Application number: 2023/91304	
What is the application for?:	Erection of two storey extension and alterations
Address of the site or building:	9, Holmfirth Road, Shepley, Huddersfield, HD8 8BB
Postcode:

User comments

| rev   | description                  | drawn                    | auth                       | date                     |
|---|------------------------------|--------------------------|----------------------------|--------------------------|
| Project No<br><b>2835</b>   | Drawing No<br><b>(100)02</b> | Rev                      |                            |                          |

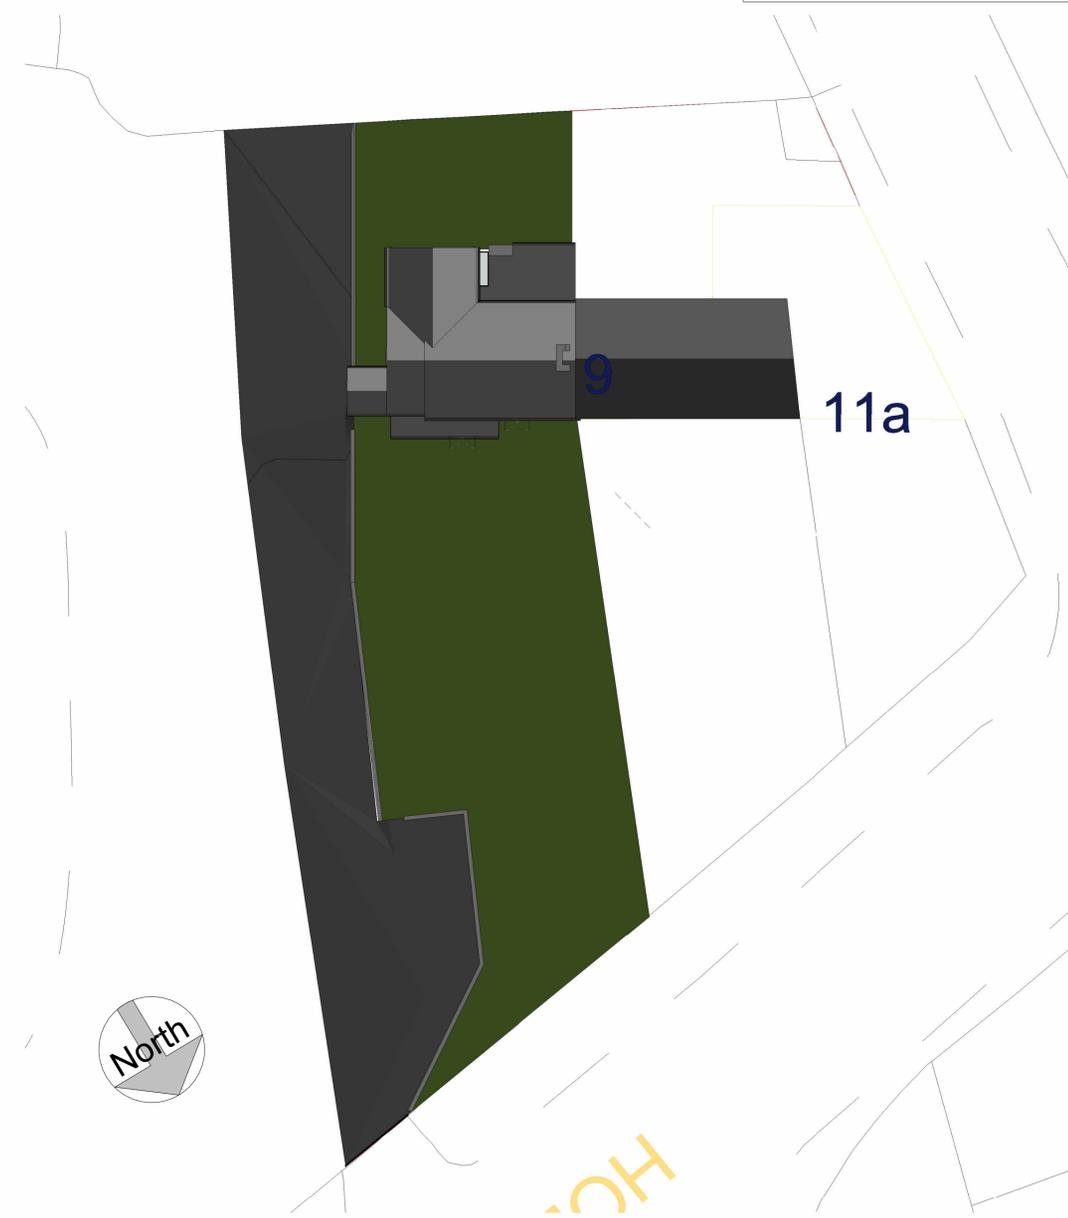
Type of comment: A general comment	
Do you wish your comments to be published on the website anonymously?	No
The drawings are for the new extension come way over in to my garden and will be on my land way more than we discussed I would sell.
